**ADC Planning Consultation
Response from the Conservation Officer**

Application Number	AW/267/15/HH
Address	68 The Drive Aldwick PO21 4DS
Description	Minor Amendments to previously approved application AW/344/14/HH for extensions & alterations - This application affects the character and appearance of the Craigweil House Conservation Area
Case Officer	Mr. D Easton

Objection

PROPOSED ROOF PLAN 1:200

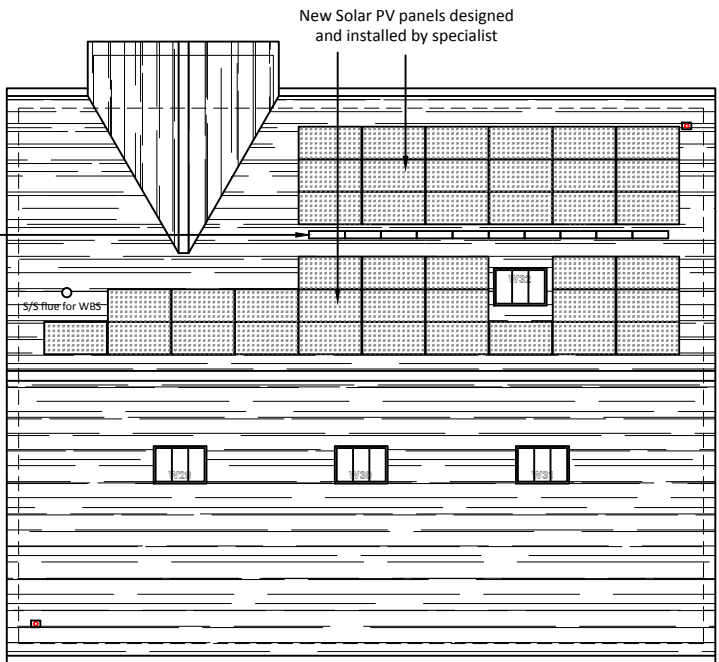
The rear elevation includes a revised balcony with a spiral staircase, glass screening, roof-light and solar panels. It is considered that this results in a visually cluttered elevation. The solar panels cover a considerable amount of the roof and are not considered to make a positive contribution to the property or the area.

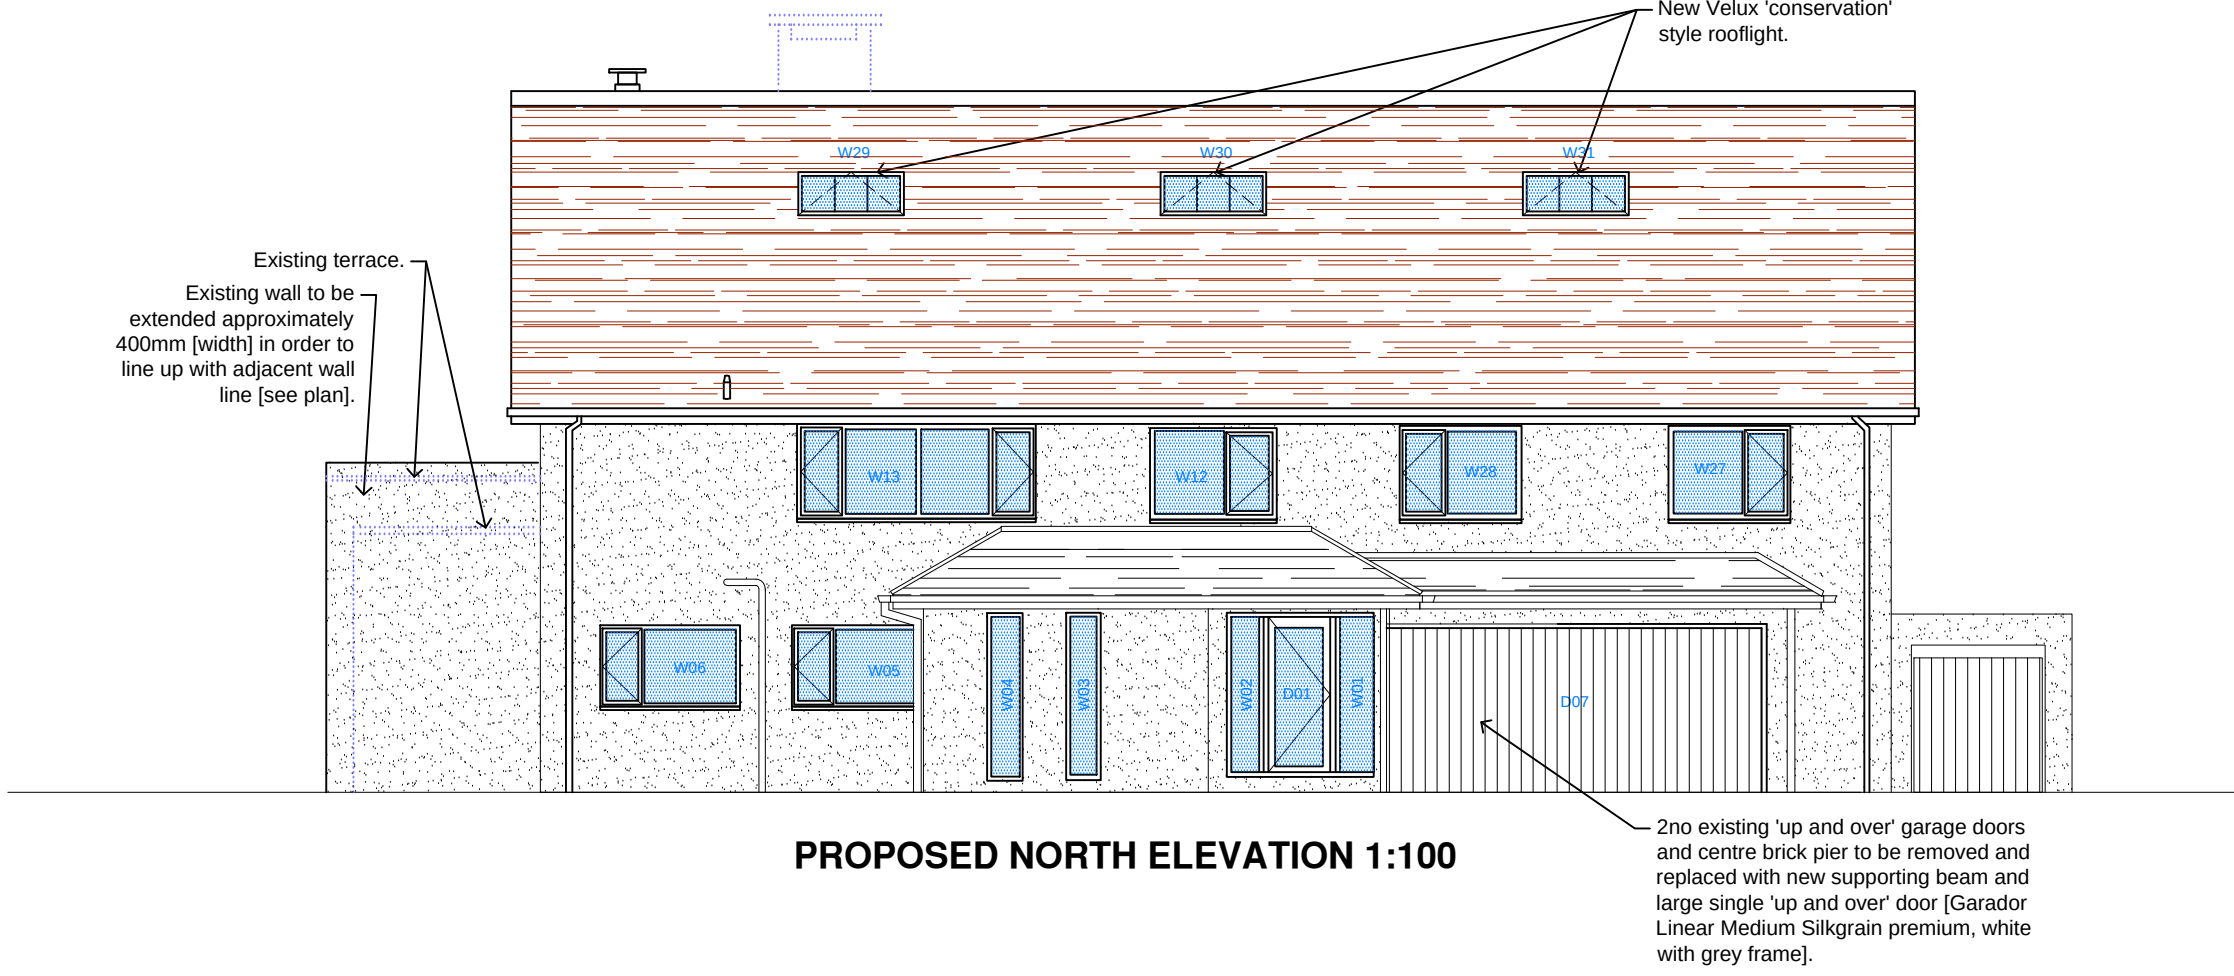
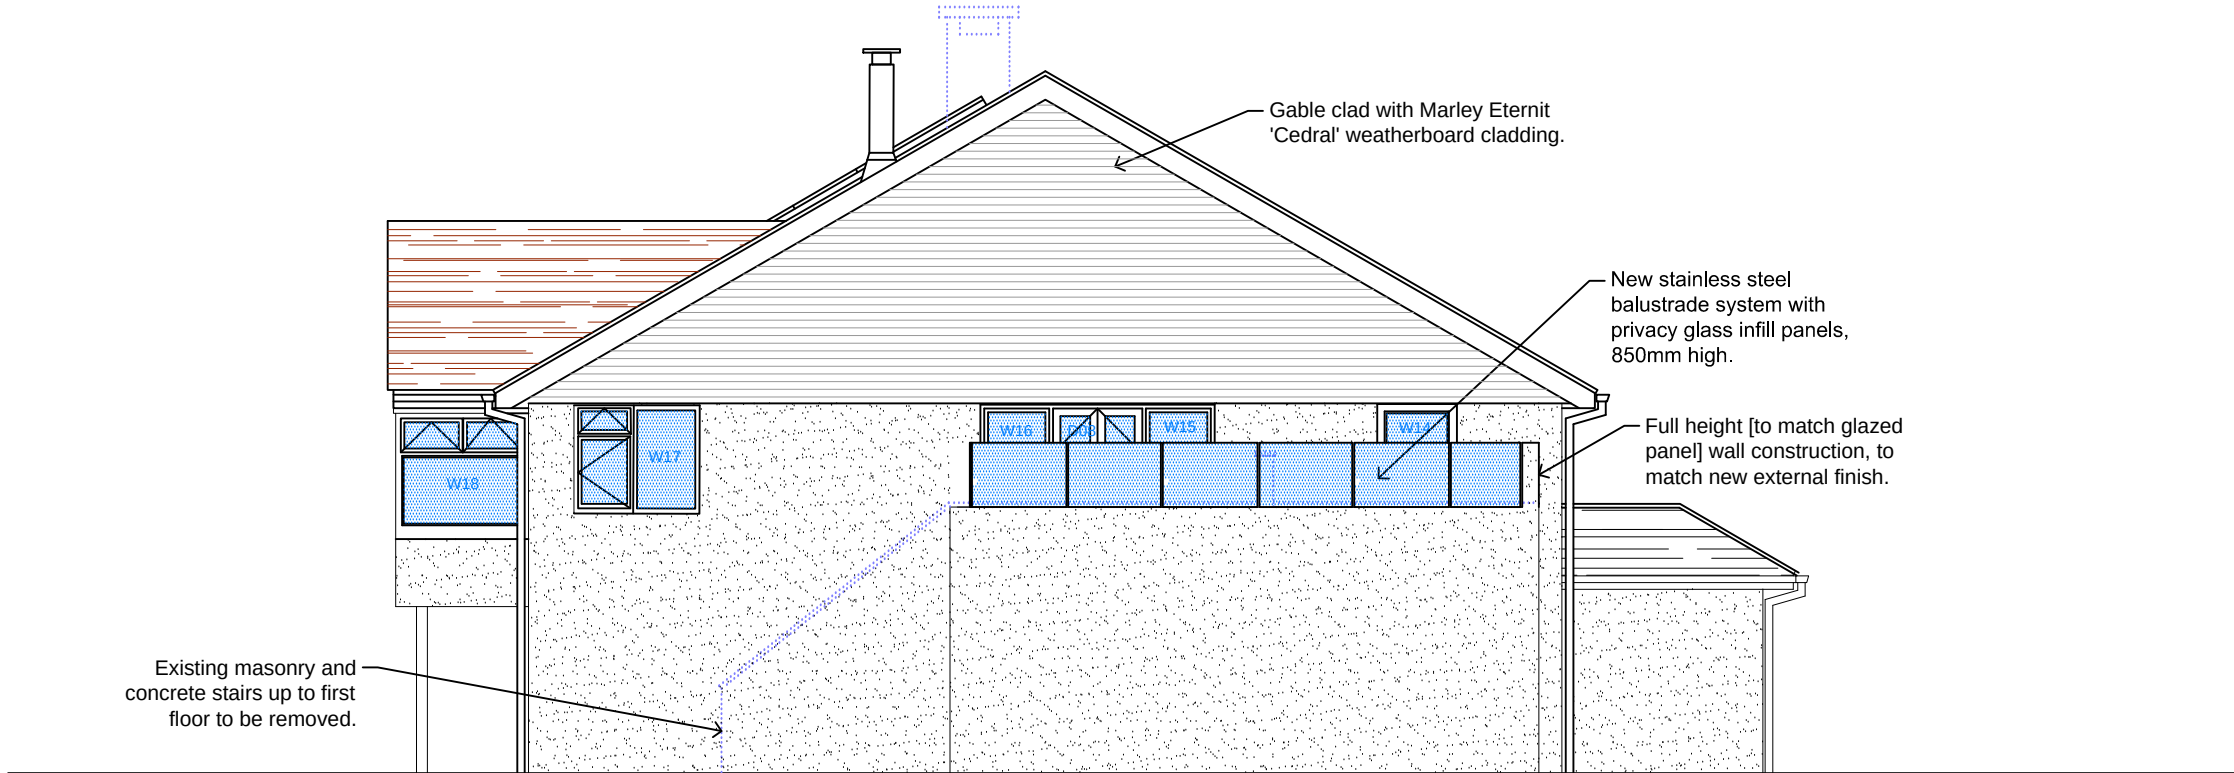
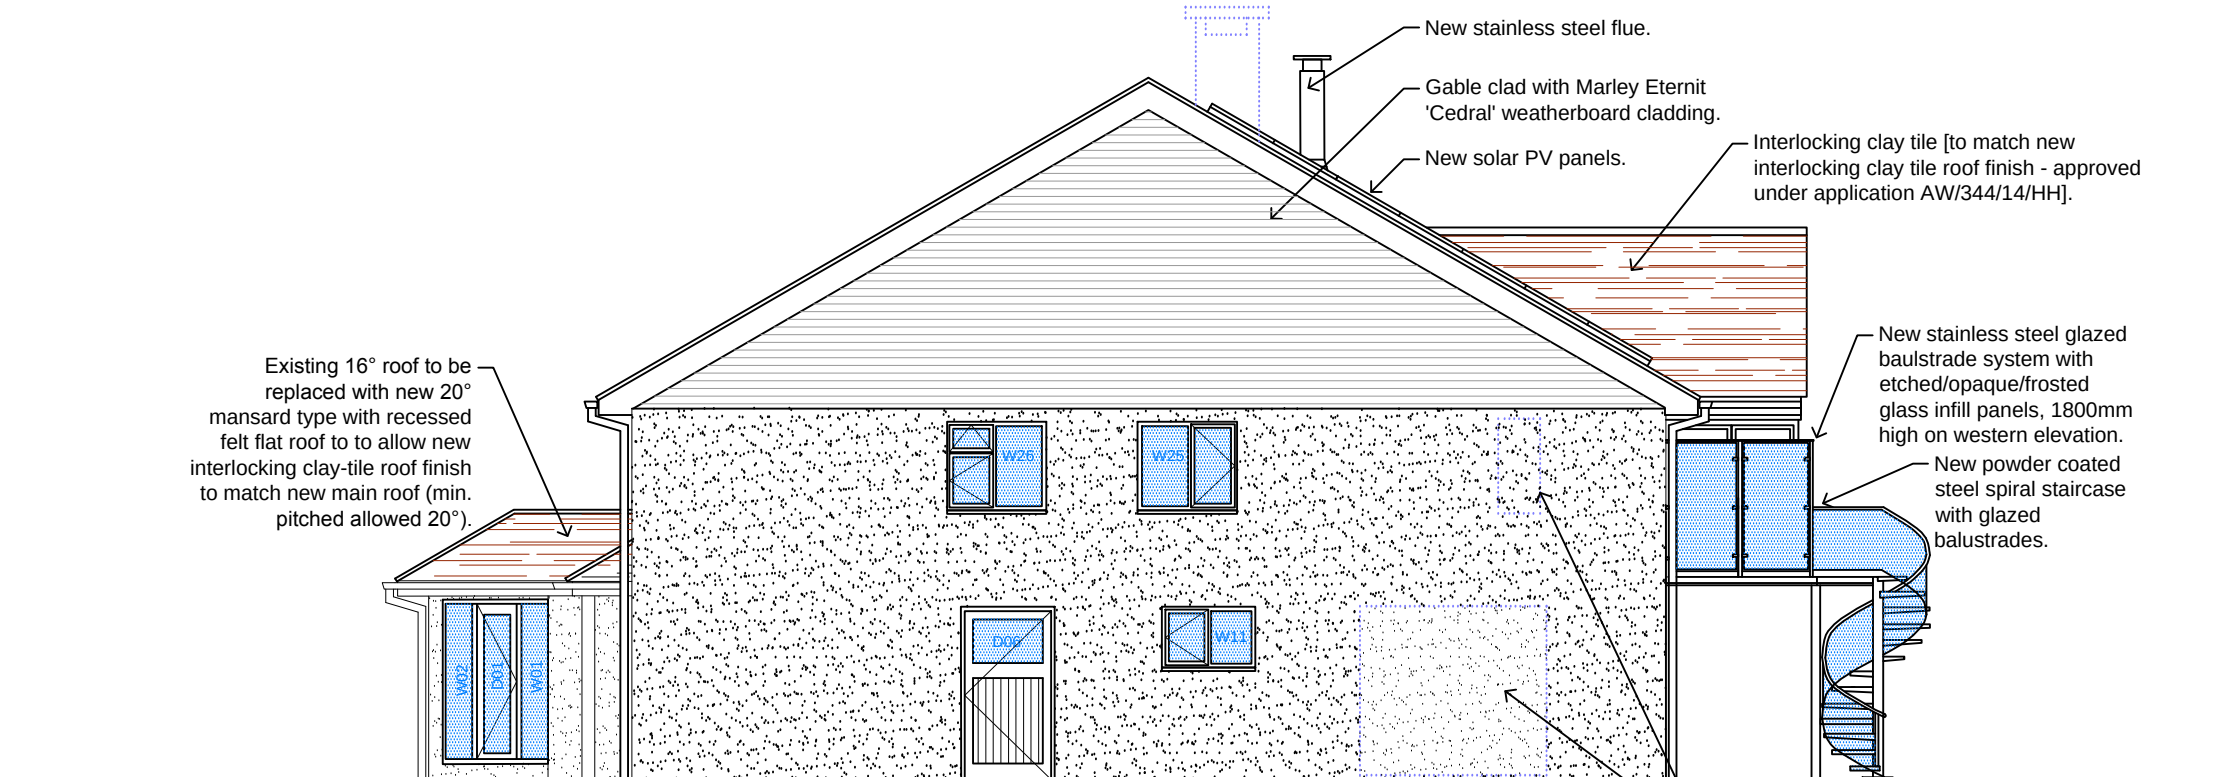
A noteworthy element of the conservation area is the lack of street lighting. As a consequence, the area maintains a tranquil character with little light pollution. The installation of LED downlights into the eaves soffit at 2m centres is considered to conflict with this established character. The introduction of the lighting will be visible from both the street to the front and the beach to the rear. It is therefore considered that such a feature is harmful to the various heritage assets affected by this proposal.

The introduction of grey windows is problematic in that it does not reflect those found within the neighbouring properties or the conservation area generally. The use of such a colour is further enhanced through the introduction of the grey Marley Eternit cladding. This cladding covers a substantial amount of both gable elevations and the 'bay' window on the southern elevation. Both elements are therefore considered to be harmful and detract from the character of the conservation area.

In addition, the combination of coloured materials is harmful; the use of white render, grey windows and cladding along with a brown roof results in an unsympathetic colour combination. It is suggested that an alternative colour to the proposed grey should be used.
